**Consultation Response from KC Highways**
**2019/90502 Land off, Fernside Avenue, Almondbury, Huddersfield, HD5 8PH**
**Erection of 10 dwellings**
**Date Responded: 22/03/19**
**Responding Officer: JT**
**Responding Ref: K11-7SW/22**

This application seeks approval for the erection of ten dwellings at land off Fernside Avenue, Almondbury.

SCALE: 1:250 @A3
 DATE: FEB 2019
 DRAWING NO: 1901502

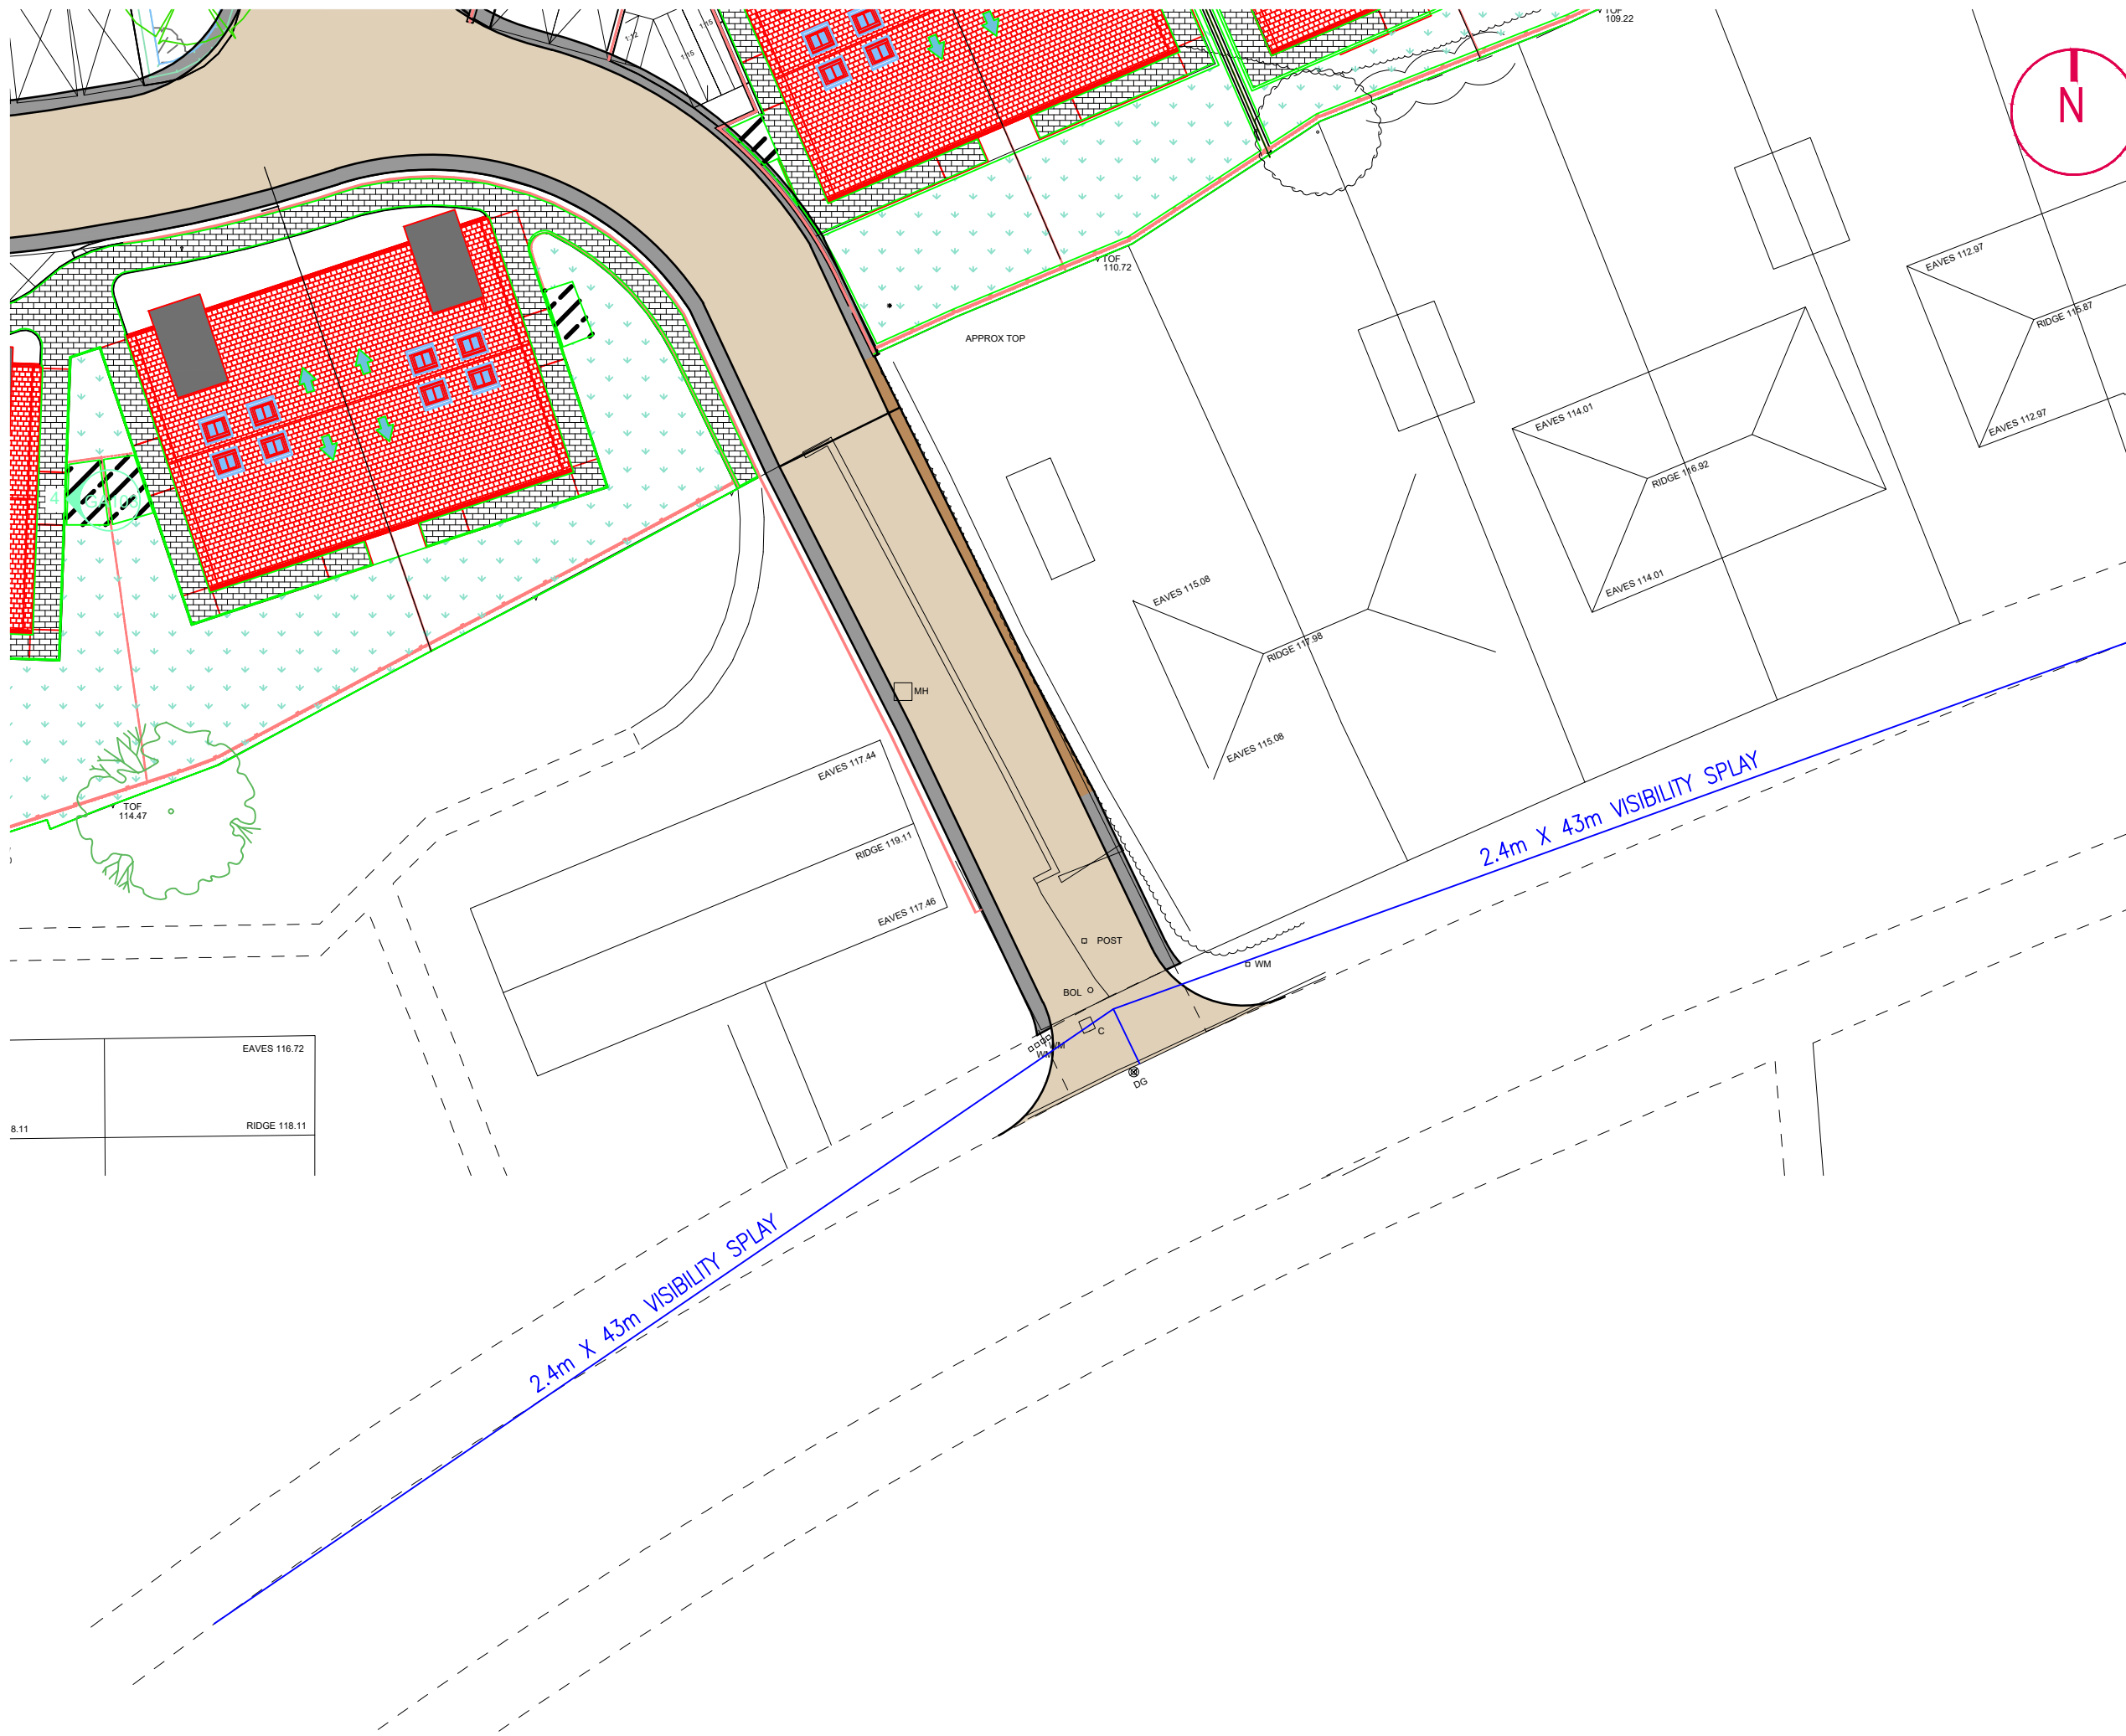
Although there appears to be around 7.2m of width available to create a new access, no detailed design has been provided by the applicant. Visibility splays have also not been demonstrated, but should easily meet the requirements for a 30mph road given the footway is 2.8m wide at this point.

Given the constraints of the access width and size of the site, it is likely a shared surface junction will be the only available option, with a ramp at the point of access to the public highway, 4m radii provided, and a minimum carriageway width of 5m.

- Details of bin collection points demonstrated on a plan, plus storage for each dwelling within 30m of the collection point(s).
- Swept path analysis of an 11.85m refuse vehicle accessing and exiting the site in a forward gear demonstrated on a plan.
- Detailed design of the proposed access onto Fernside Avenue including dimensions of carriageway widths, junction radii, etc.

KIRKLEES REFUSE VEHICLE 2018	
OVERALL LENGTH	11.850m
OVERALL WIDTH	2.500m
OVERALL BODY HEIGHT	3.749m
MIN BODY GROUND CLEARANCE	0.302m
TRACK WIDTH	2.490m
LOCK TO LOCK TIME	6.00s
WALL TO WALL TURNING RADIUS	11.000m

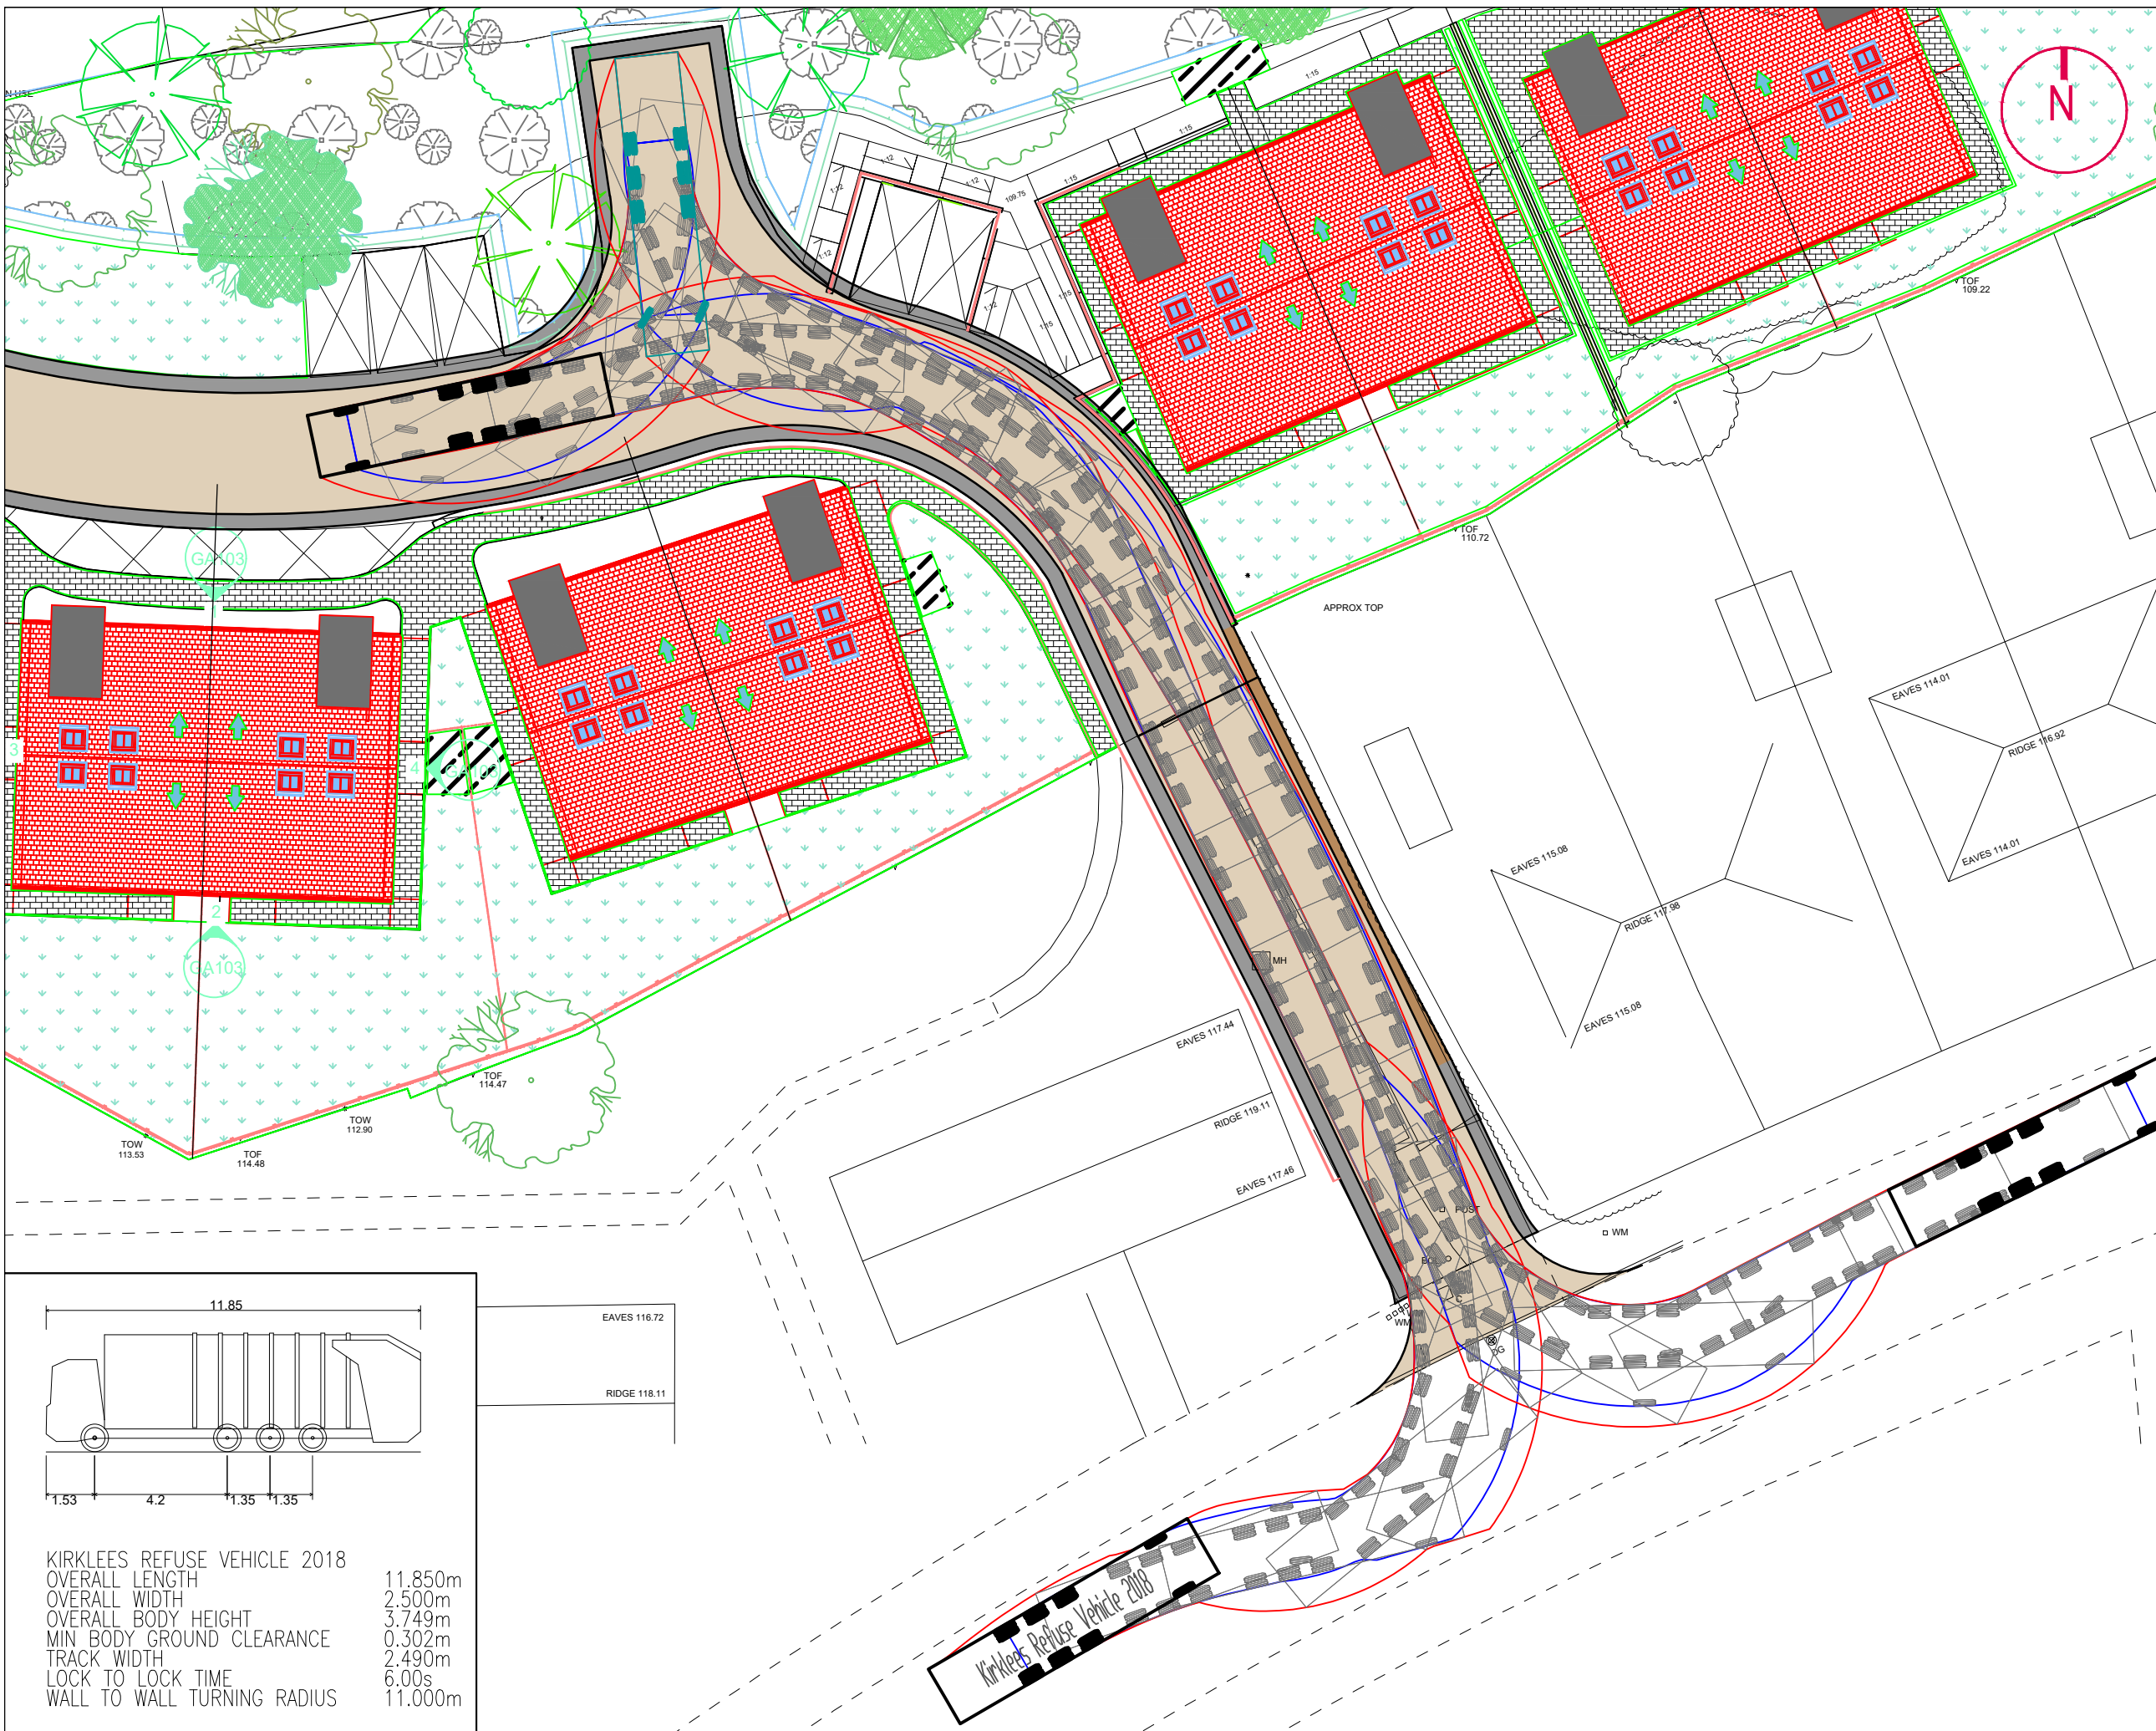
Whilst bin storage is demonstrated, no bin collection points are shown on drawing no. GA101. Some storage points are well beyond the acceptable distances from the collection vehicle. Depending on how this is resolved, some of the dragging distances from storage points may exceed the 30m maximum recommended. The turning facility is welcomed and may aid refuse collection, but swept path analysis would be required showing that an 11.85m refuse wagon can turn within the site. Access and egress by a fire appliance in a forward gear will also be required.
